**Application Reference:** 2026/0176

**Site Address:** 10 Tivy Dale Close, Cawthorne, Barnsley, S75 4ER

**Introduction:** This application seeks full planning permission for the conversion of integrated garage to habitable space, erection of front porch, erection of single detached garage to side, install of dropped kerb, alterations to front landscaping, removal of side door and install of rear door, install of new render to property, changes to both dormer's material and changes to various windows of the dwelling.

Title  
**Proposed Plans**

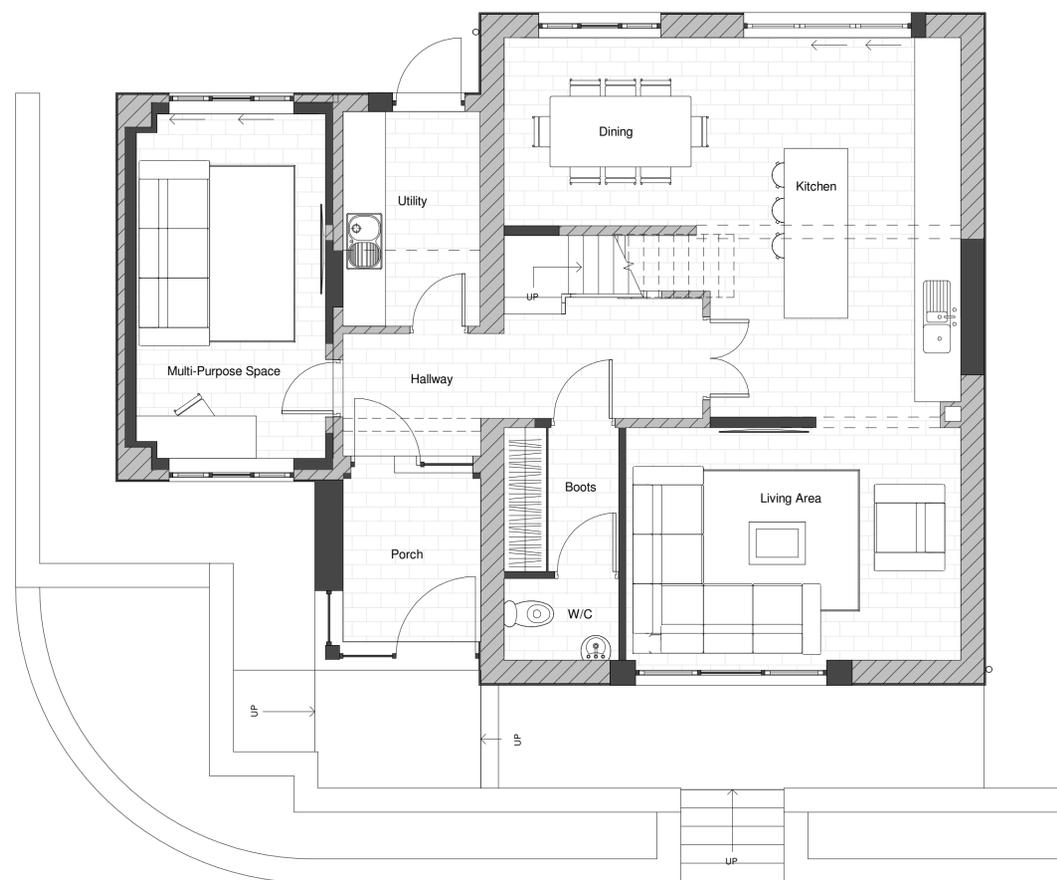
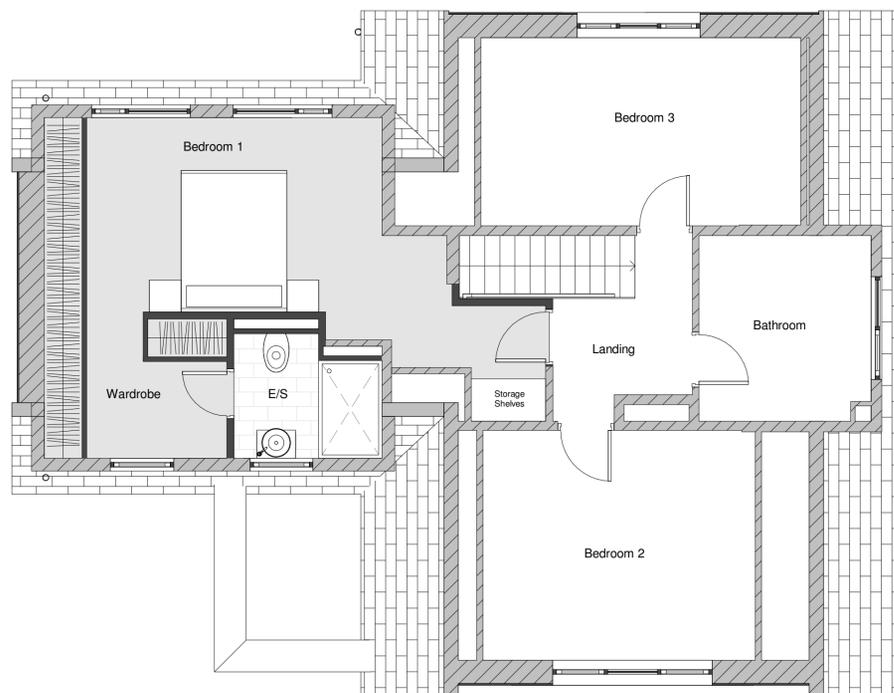
With an existing footprint of approximately 95sqm, the previously approved front and side wraparound extension of approximately 21sqm was considered proportionate in scale to the existing dwelling. With the proposed extension now being just a ground floor, front extension, with an approximate footprint of 6.5 sqm and front projection of 2.8m, there would be little or no impact on the scale of the dwelling, especially with the extension still set back from a significant section of the front elevation.

The existing dwelling features multiple flat roofed dormers with most, if not all being original features of the dwelling. Whilst the previous proposal sought to increase the size and partially relocate the dormers, the current proposal appears to refurbish them, with only a marginal increase in size. The dwelling also features an integrated garage, this would be converted to habitable living space, with the garage door being replaced with a window to match the proposed re-design of the dwelling.

Title
Proposed Elevations

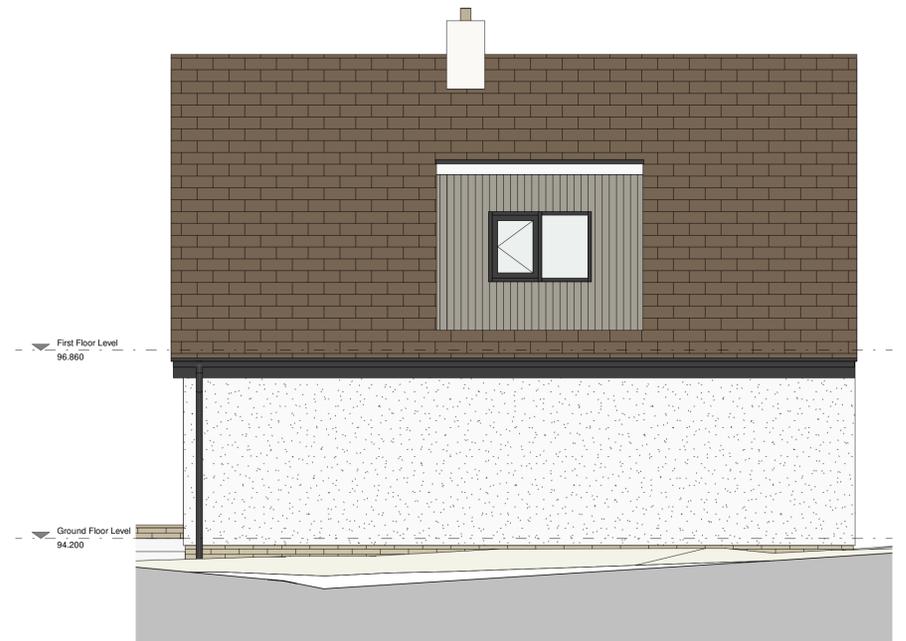
The most significant change to the design and character of the dwelling, more notable than the modest sized extension is the overall re-design of the dwelling, particularly its prominent front elevation. Whilst currently sharing common materials with most nearby dwellings, as noted in the previously approved application, it would have been difficult to refuse the proposed rendering of the dwelling, in white. The neighbouring dwelling of No.8, which is the most similar dwelling to the application dwelling has already been completely rendered in white, along with a significant amount of white render on the much larger dwelling of No.6.

Whilst many of the window openings, which would not be removed or replaced by doors, would remain broadly the same size, the proposed frames would be of a new design across the dwelling, including within the dormers. Definitive material choices and colours for the proposed doors, windows, and dormers have not been confirmed; as with the previous application, if approved. A condition would be added to the decision notice, requiring the written approval for the final material and colour choices for windows and dormers.

There are no new windows proposed on the first floor of the dwelling, but windows in all three dormers are proposed to be replaced, with windows in the front and rear dormers being repositioned and resized. There would be no impact arising from these changes on the front elevation. For the rear elevation, despite an increase and reposition of the existing windows, the actual glazing has only increased by approximately 0.04 sqm. With the dormers themselves being original, and with the side elevation of the rear neighbour dwelling facing the rear elevation of the application dwelling, the impact of the refurbished dormer would be considered as limited.

3. Upon commencement of development, details of the proposed external materials shall be submitted to and approved in writing by the Local Planning Authority. The development shall be carried out in accordance with the approved details
